From: Amber Willard
Sent: 12 May 2025 14:26
To: Planning.Responses
Subject: FW: BN/46/25/PL
Attachments: Land South of Wandleys Lane Eastergate BNG HMMP Rev 2_.pdf; Land to the South of Wandleys Lane, Eastergate - BNG Metric - Rev 2 (May 25).xlsm; 230010_16A_proposedlandscapestrategy-A1 SHEET.pdf; 230010_05A_proposedsiteplan-A1 SHEET.pdf; bn-46-25-pl action sheet.docx

From: Jonathan Best <Jonathan.Best@arun.gov.uk>
Sent: 29 April 2025 14:44
To: Planning.Responses <Planning.Responses@arun.gov.uk>
Cc: Amber Willard <Amber.Willard@arun.gov.uk>
Subject: BN/46/25/PL

Land South of Wandleys Lane Eastergate PO20 3SE.

I have reviewed this application with regards to ecology and Biodiversity Net Gain.

**Figure 2.** Proposed site plan (VIVID Design Studio, Drawing No: 230010\_05).

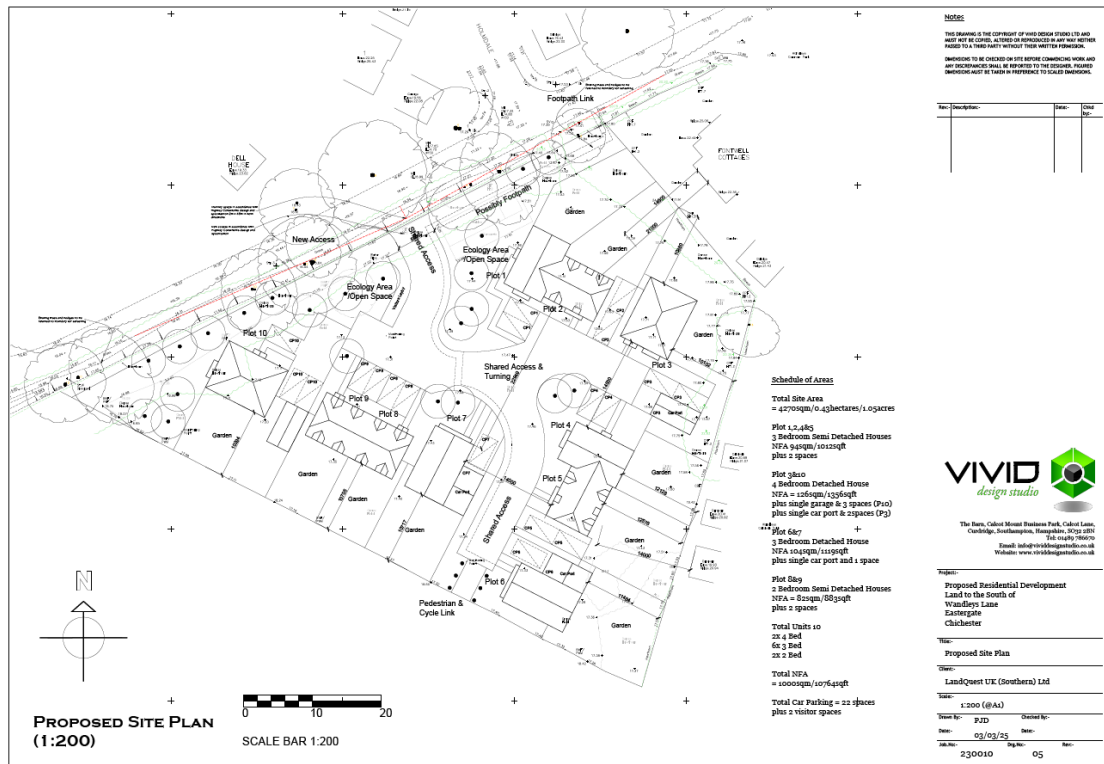
The metric calculations and BNG HMMP include enhancement of modified grassland to other neutral grassland delivering 0.40 habitat units however, the landscape plans show 20 trees proposed for the same areas.

If the trees are planted on the modified grassland the enhancement to other neutral grassland is unlikely to be successful especially as the tree planting aims to provide a continuous canopy. This requires clarification as failure to deliver the grassland enhancement would mean that the development could fail to meet the minimum 10% net gain.

Please find attached the revised reports and drawings which address the ecology officers' comments. This includes a revised BNG Habitat Management and Monitoring Plan, BNG metric, proposed landscape strategy and proposed site plan.
